WANTAGE TOWN COUNCIL

RESPONSE TO SESRO THAMES WATER RESOURCES MANAGEMENT PLAN

Figure 3.3 Potential intake / outfall structure location options

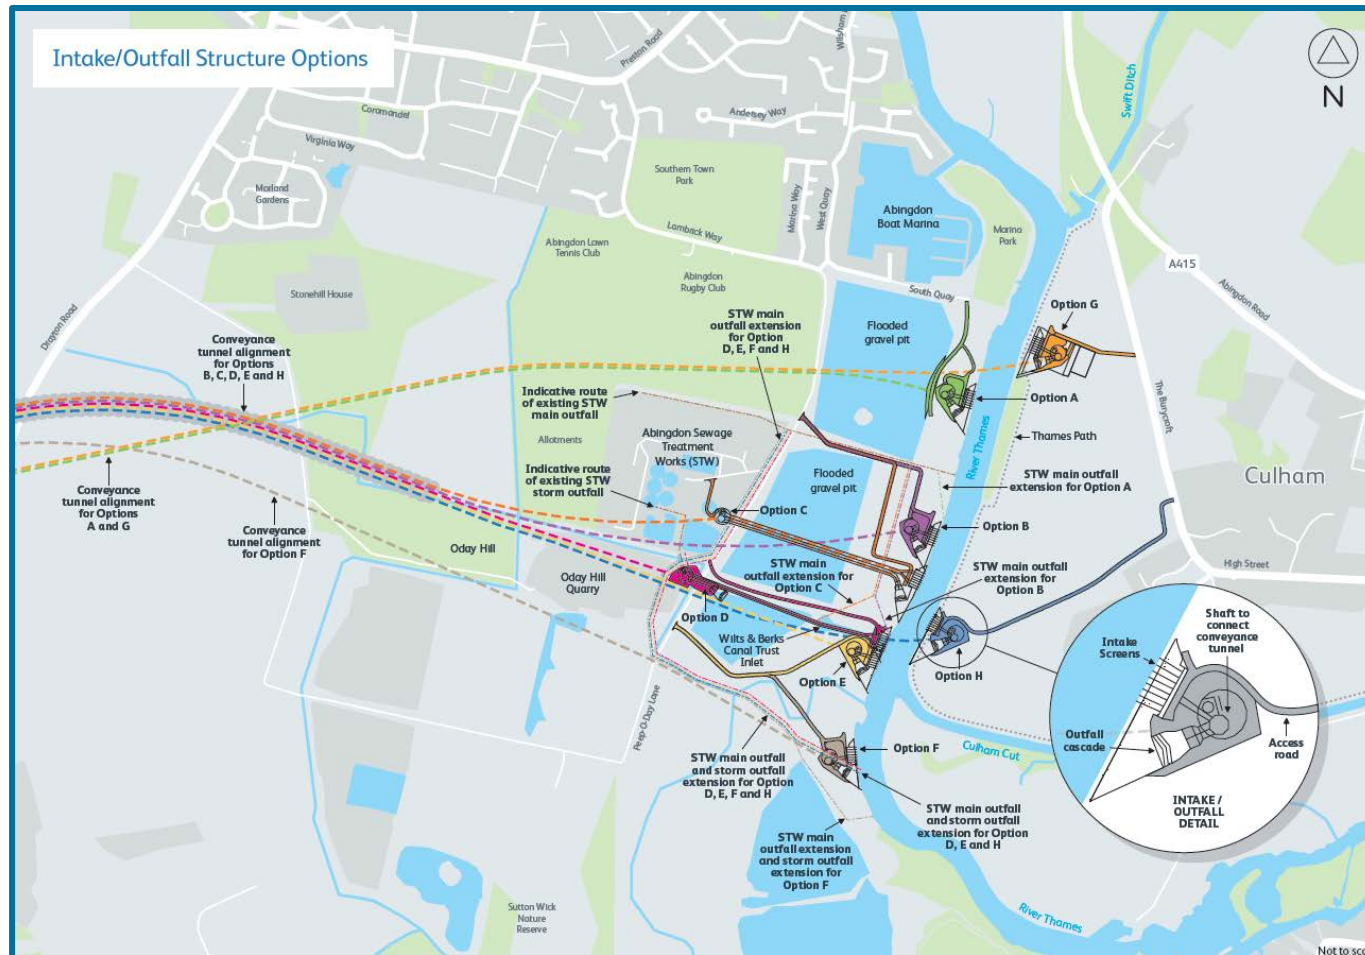
All the options for the water intake location are close to both an existing sewage site and two historic landfill sites. Furthermore, water from the Thames is periodically unfit for use in the reservoir and abstraction upstream at Farmoor reservoir has been stopped. Sites close to or downstream of the Abingdon sewage works and waste disposal sites will add to the already high bacterial and contamination load. There appears to be no existing design for the intake/outfall site plant.

Figure 3.4 Main access road options

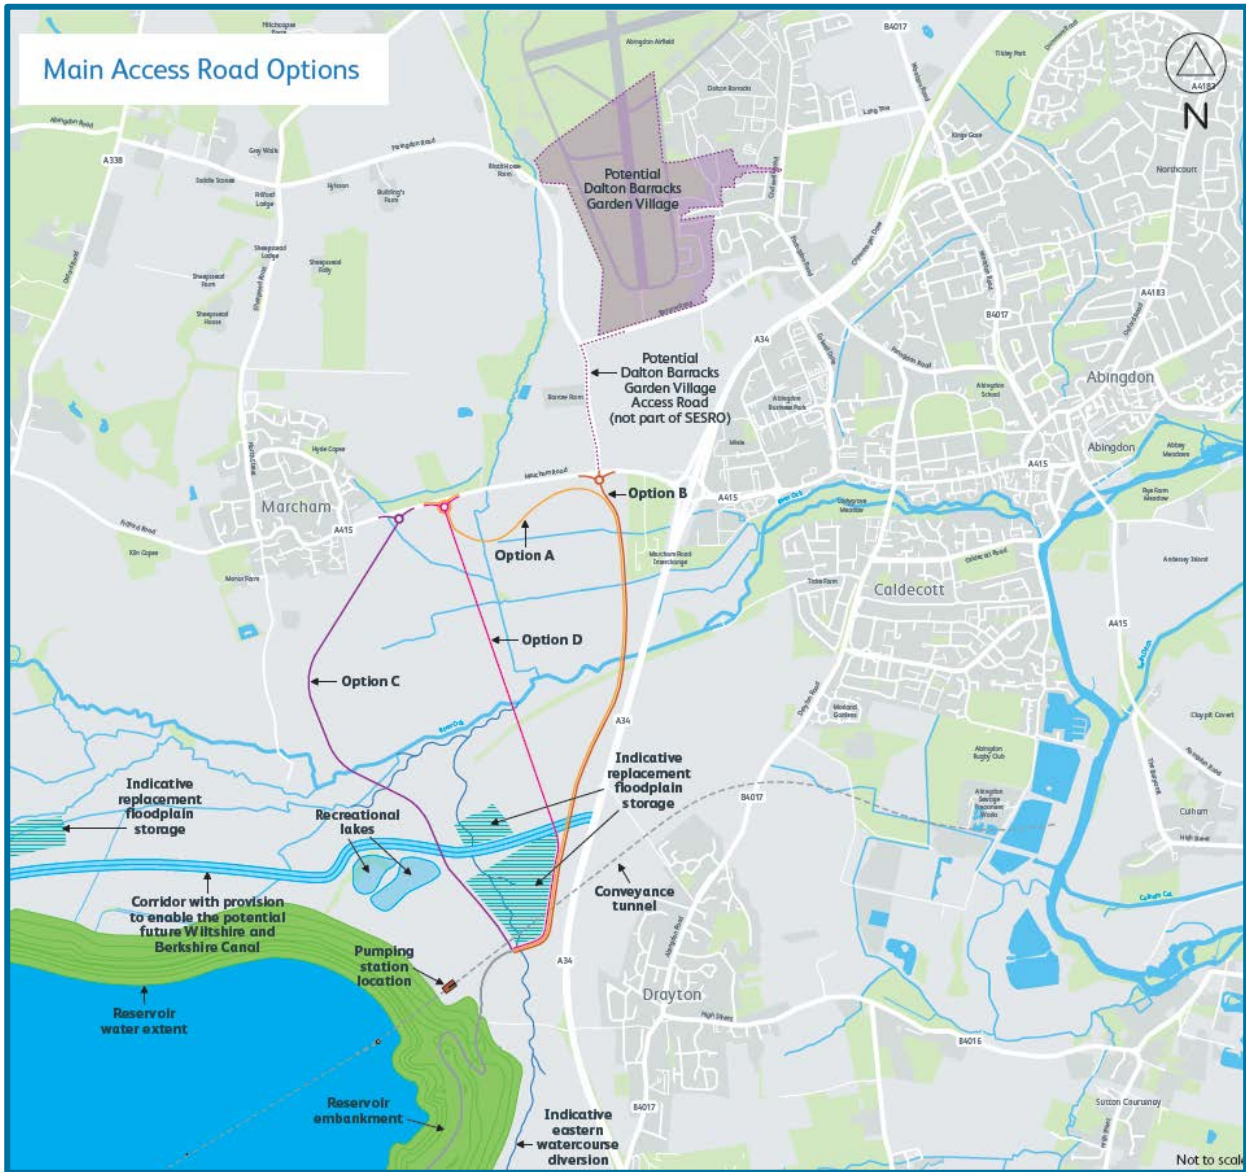
The construction of a new access road (Option B) raises significant environmental concerns. Building this road will result in habitat destruction and increased carbon emissions during construction. The project should adhere to "net zero carbon" principles, utilizing frameworks such as BREEAM to ensure compliance from the beginning of the design phase.

Figure 3.6 Rail sidings and material handling area – search area options

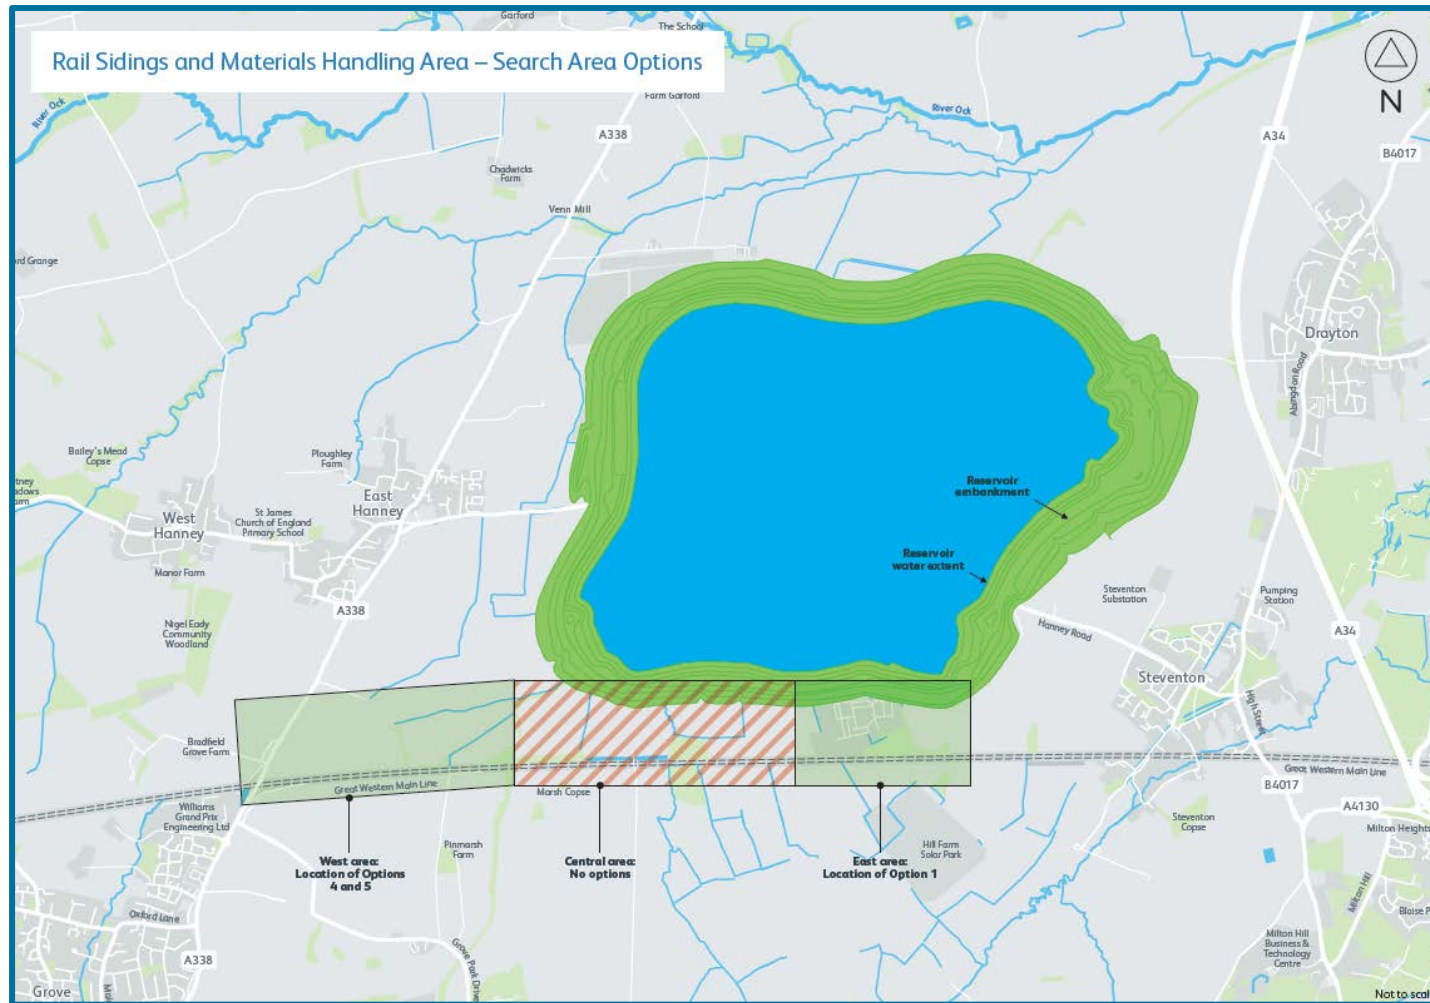
While we understand the need for efficient transportation links to the site, we are concerned that the proposed rail sidings might interfere with the future development of Grove station. As a result option 4B or 5 are preferable. It is crucial to ensure that the new infrastructure does not obstruct or complicate the planning and construction of Grove station, which is important for improving regional connectivity and public transport options and any discussion with Network rail must include discussion of the Grove Railway Station. Additionally, the environmental impact of constructing new rail infrastructure should be carefully considered, with efforts made to minimize carbon emissions and habitat disruption.

Figure 3.7 WTW options

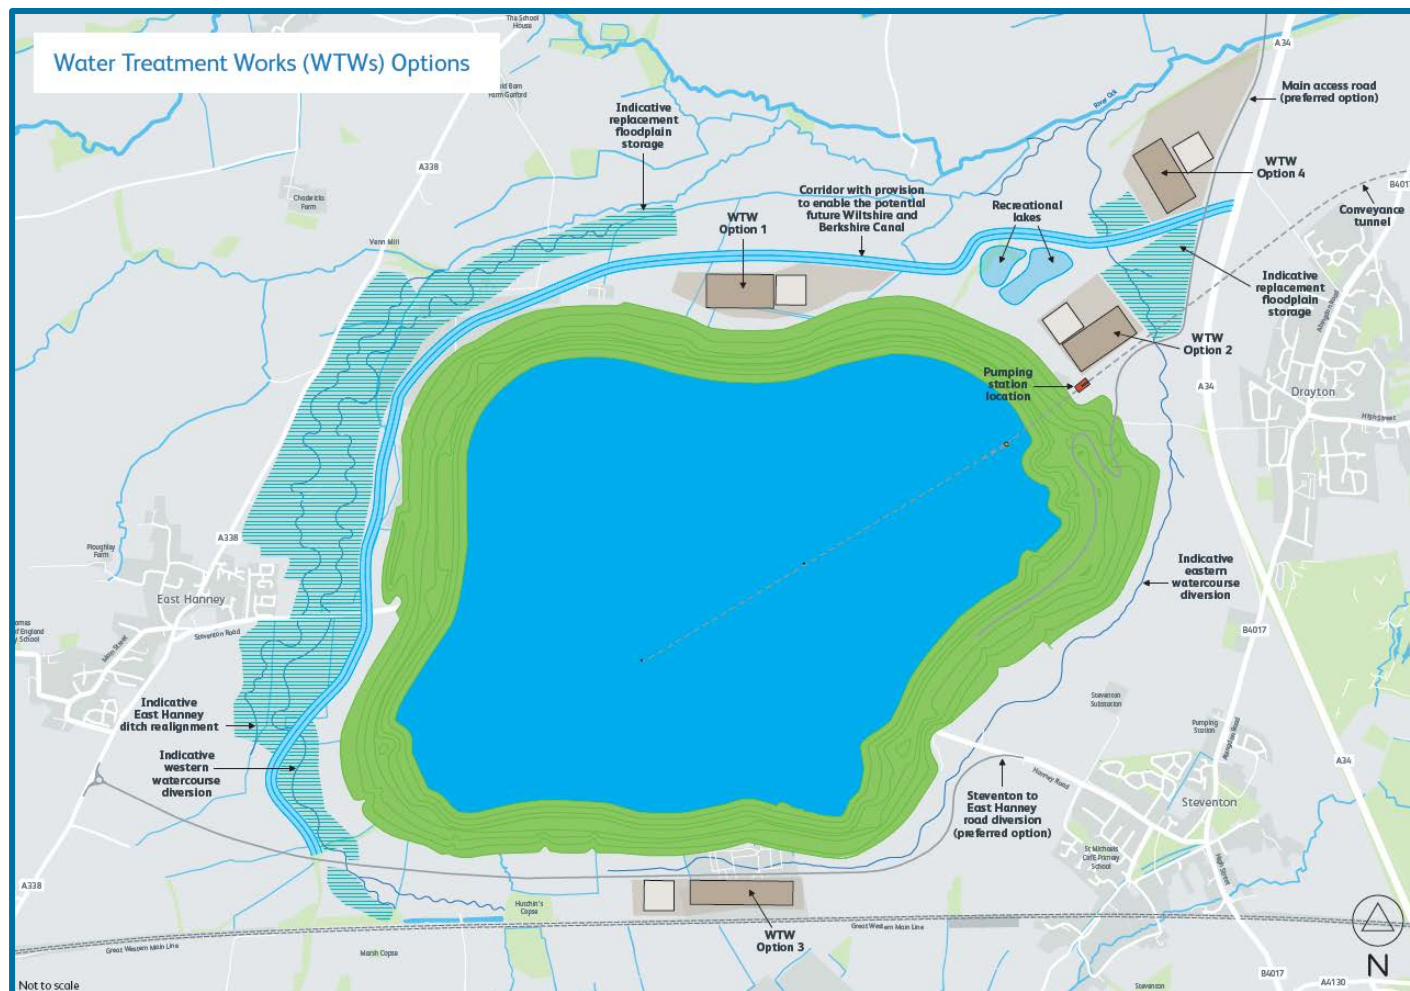
Again, the project should take on "net zero carbon" principles and using frameworks such as BREEAM from the outset is essential to ensure sustainable development.

The plans showed a sewage plant close to the current location of the water processing plant. This is not acceptable from a safety and security perspective. No sewage plant or waste disposal site should be located close to either the reservoir or the water intake site as the probability and risk of accident, maloperation, failure or permeation through ground or airborne aerosol is too great.

The water processing plant is presented as outline plan only as it is to be provided by Southern Water. It includes the provision of water purification systems which involve highly corrosive and hazardous chemicals and plant. The location of plant and storage facilities close to leisure areas is unacceptable from a safety perspective. I find it worrying that this crucial part of the plan is being provided by a third party who presumably would then also be responsible for marketing the processed water primarily within the southern region.

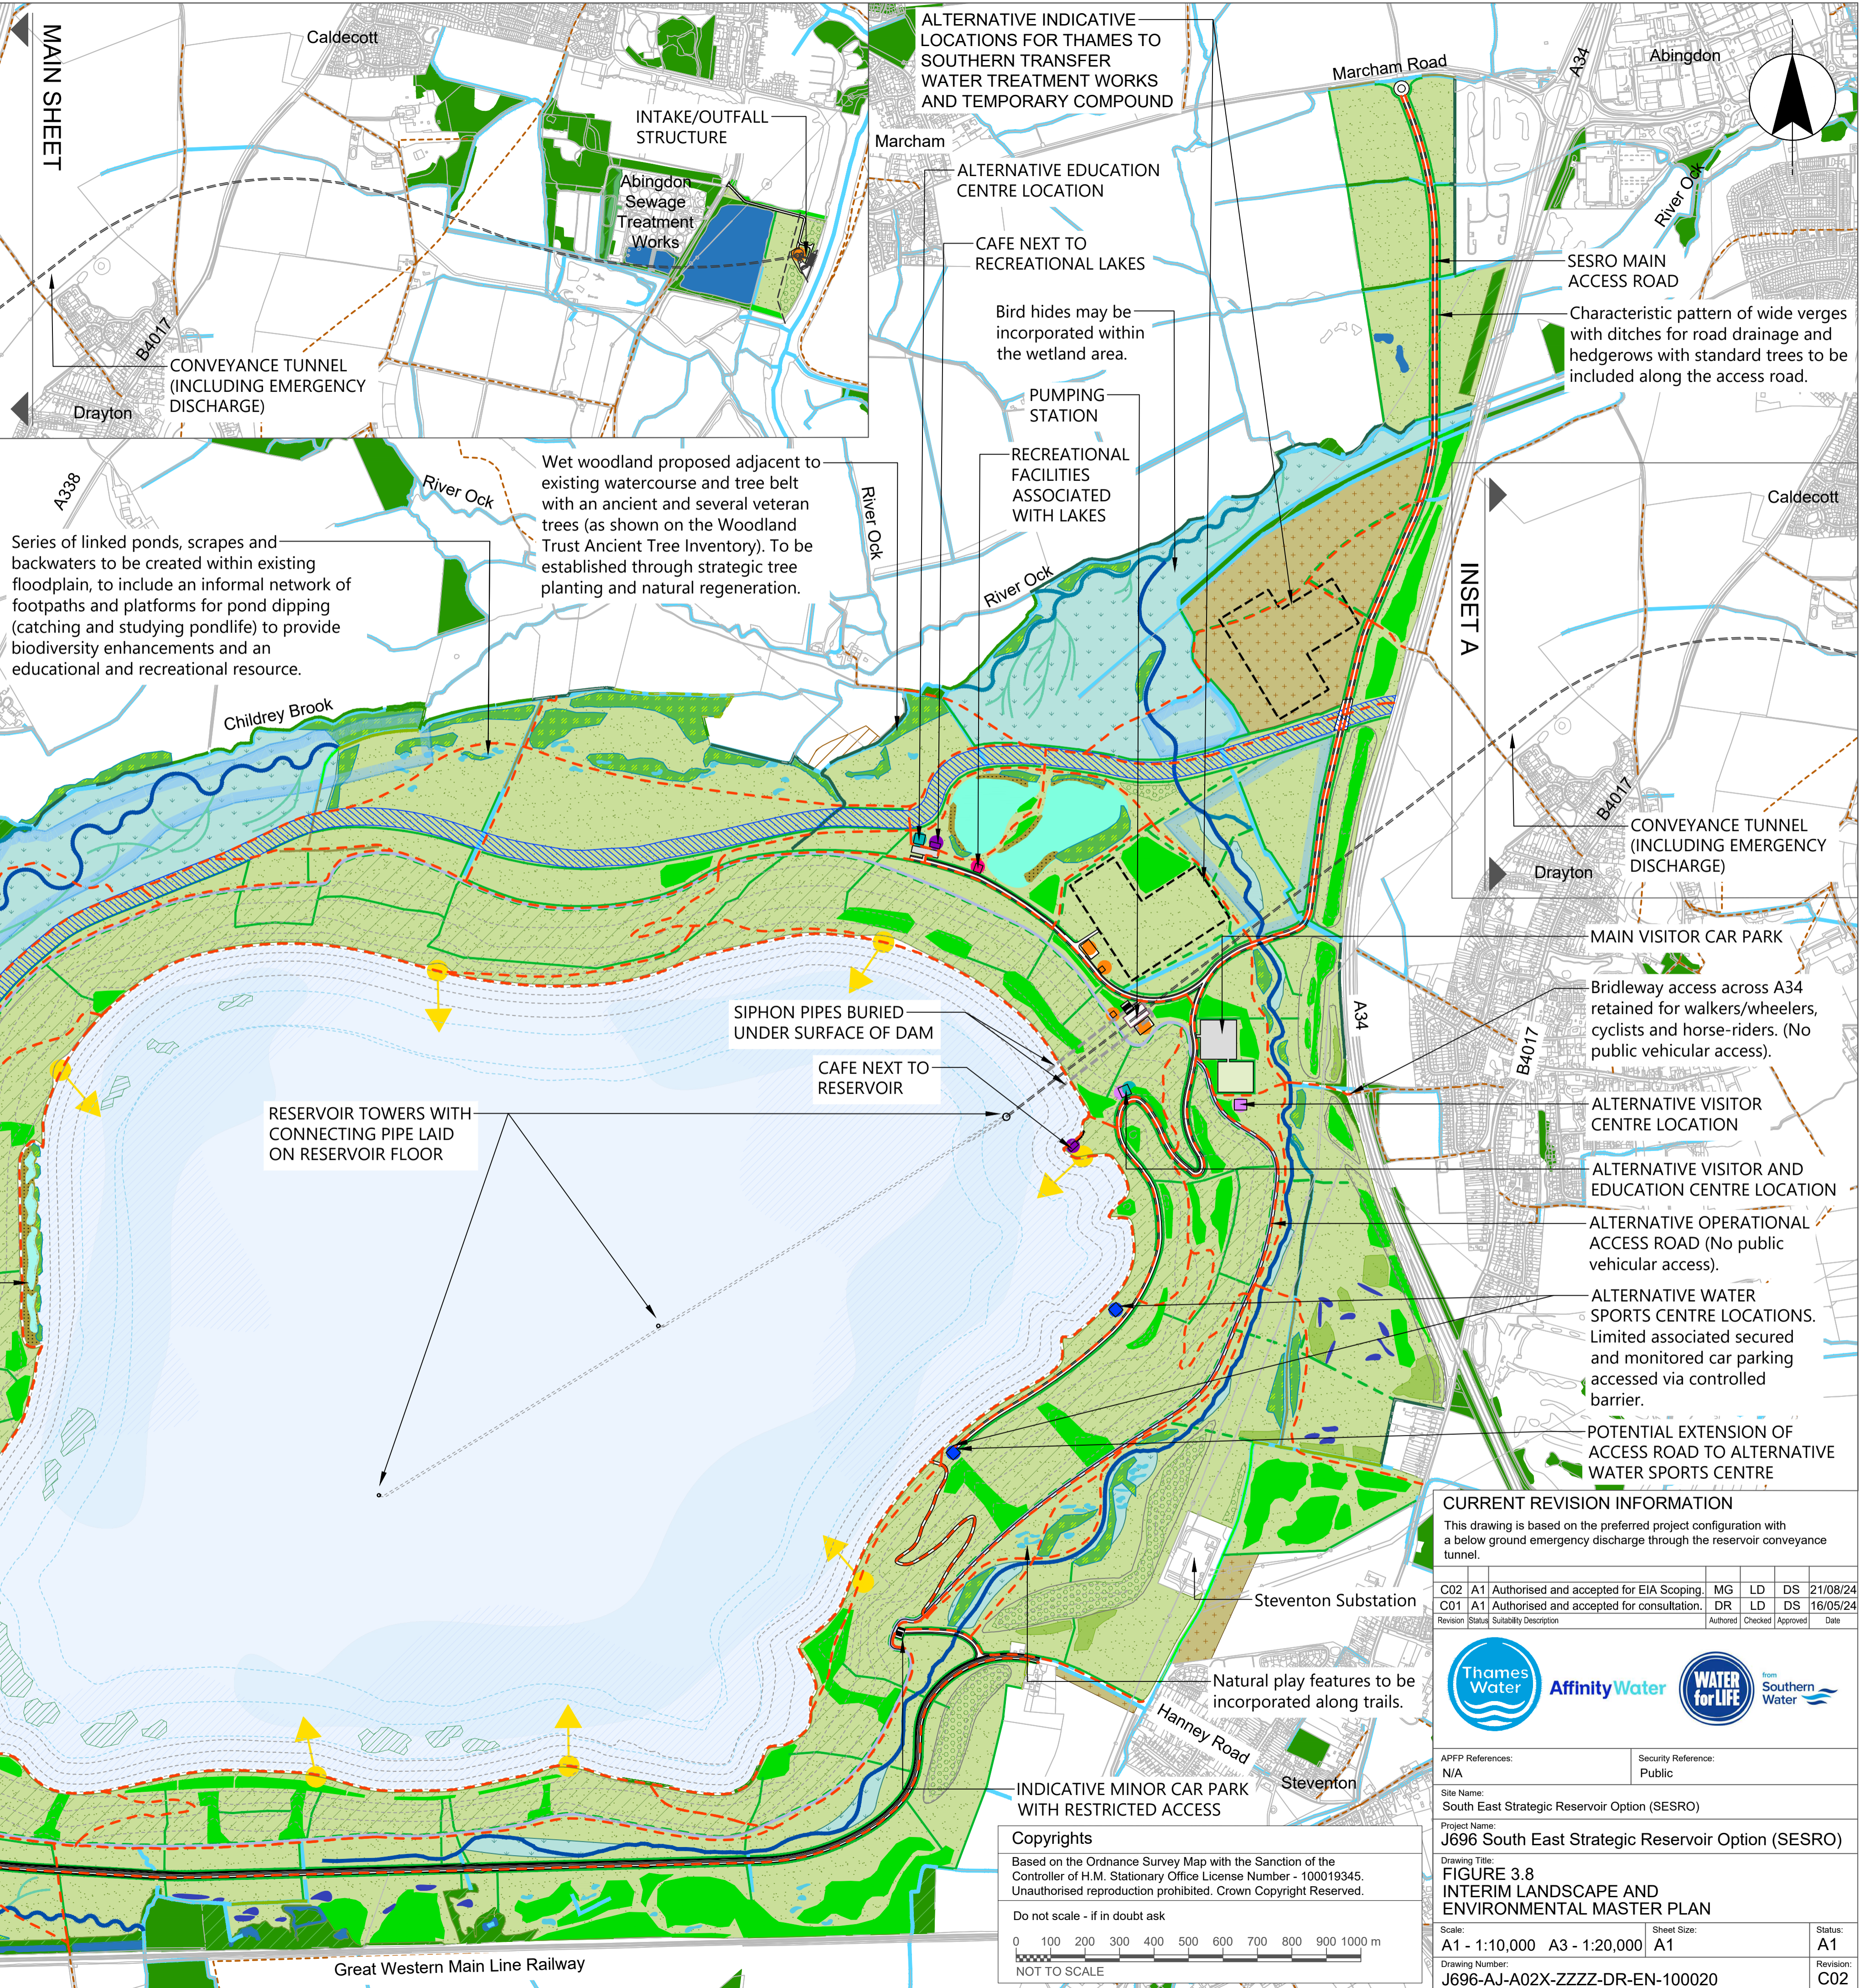
The Interim Master Plan's inclusion of wetlands and diverse ecology is commendable. However, the significant environmental impact of constructing the reservoir remains a major concern. It is crucial to weigh these benefits against the substantial carbon emissions and habitat destruction the project will cause. Additionally, given that existing reservoirs are not fully utilised due to pollution in the Thames, similar issues may arise with the new reservoir, limiting its effectiveness. The design and implementation should comply with "net zero carbon" principles and BREEAM standards to ensure environmental sustainability from the beginning.
